| <b>Application Ref:</b>            | 3/2015/0509 | <br>Ribble Valley<br>Borough Council<br><a href="http://www.ribblevalley.gov.uk">www.ribblevalley.gov.uk</a> |
| <b>DELEGATED ITEM FILE REPORT:</b> |             | <b>REFUSAL</b>   |

| <b>Development Description:</b> | Demolition of existing poultry sheds and construction of new detached dwelling. |
| <b>Site Address/Location:</b>   | Land adjacent to Southport House Sawley Road Sawley BB7 4LE.                    |

GROUND FLOOR LAYOUT
3,182sqft / 295.6sqm.

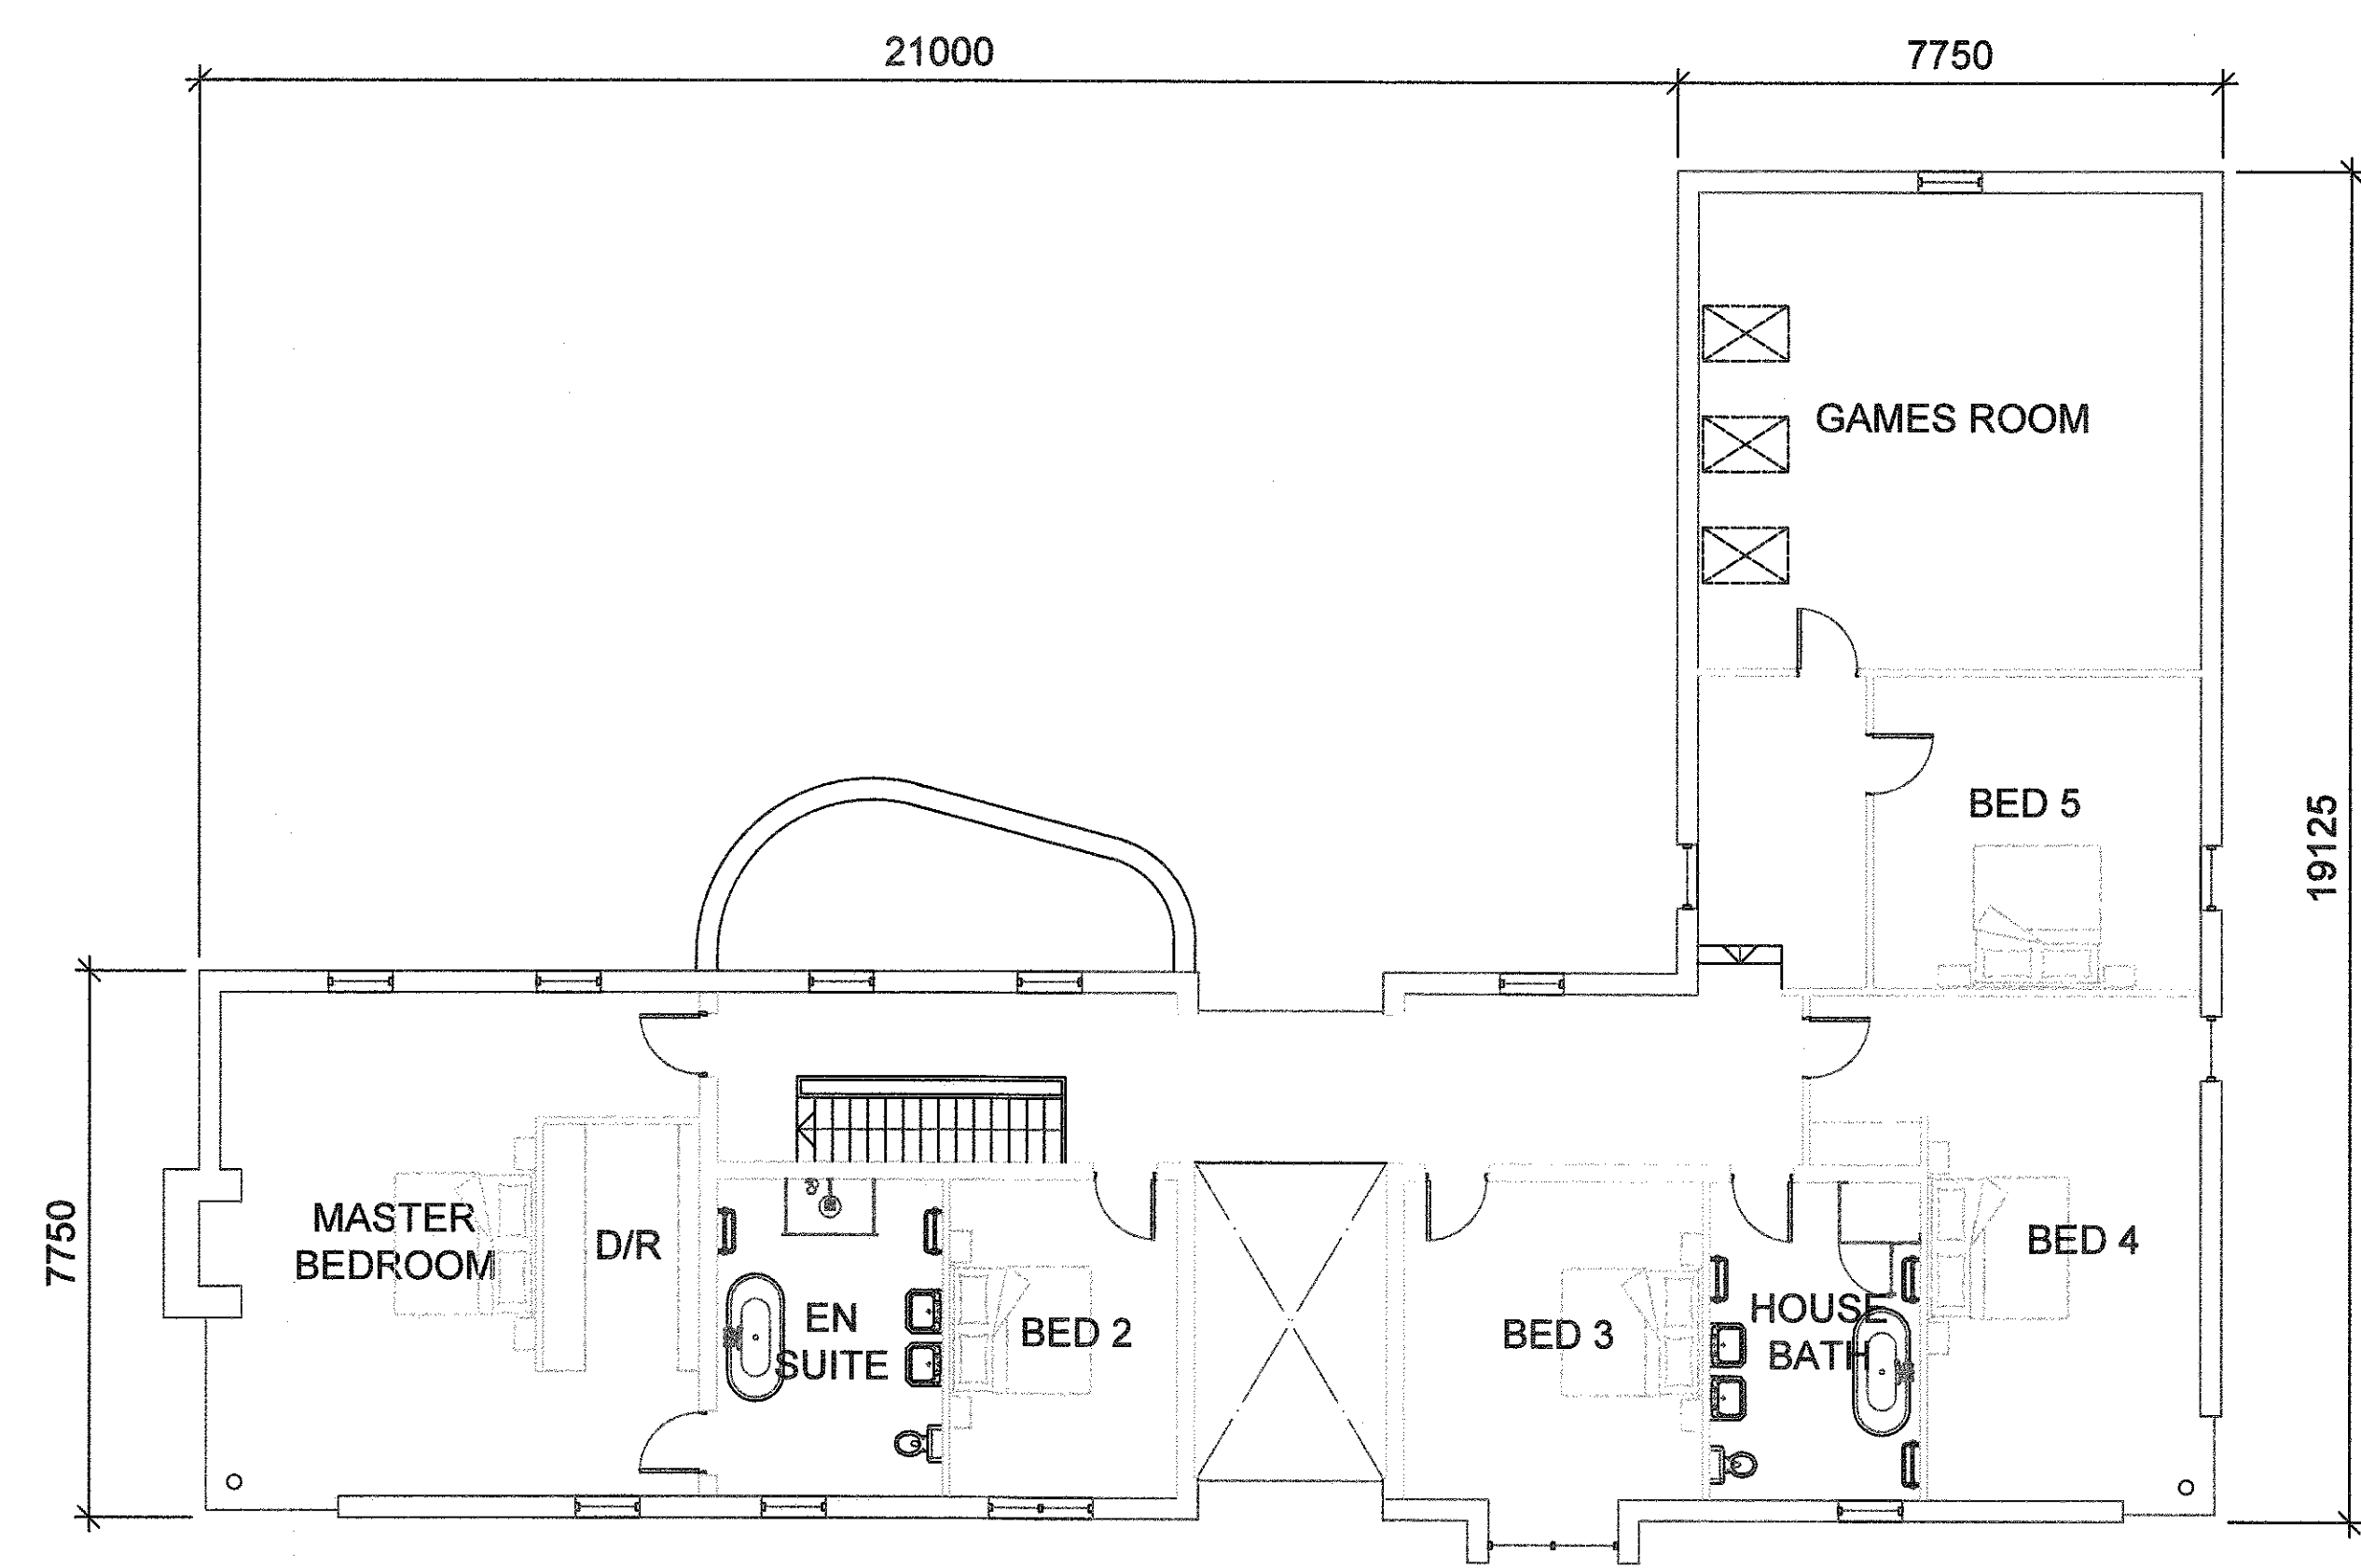
I disagree with the submitted Design and Access statement in respect to application of section 55 of the NPPF to this development. In my opinion, the design of the dwelling is not exceptional or innovative (the glass link, double garage wing and large lawned areas are particularly incongruous) and for the reasons above cannot be considered to be sensitive to the defining characteristics of the area.

| RECOMMENDATION: |   |
|-----------------|---|
| 01              | The proposal's location, size, height, materials and landscaping results in a prominent and incongruous development which undermines Sawley Conservation Area's distinct linear village morphology, its visual hierarchy of buildings ('Focal Buildings') and the significance of its open spaces surrounding Sawley Abbey. This is harmful to the character and appearance of Sawley Conservation Area, the setting of listed buildings (principally Southport House) and the cultural heritage of the Forest of Bowland Area of Outstanding Natural Beauty. This is contrary to Key Statement EN5 and Policies DMG1, DME4 and DMG2 of the Ribble Valley Core Strategy and the National Planning Policy Framework Paragraph 17 (conserve heritage assets in a manner appropriate to their significance), Paragraph 60 (reinforce local distinctiveness), Paragraph 115 (conserve cultural heritage), Paragraph 131 (development sustaining and enhancing the significance of heritage assets and positively contributing to local character and distinctiveness) and Paragraph 132 (great weight to conservation). |
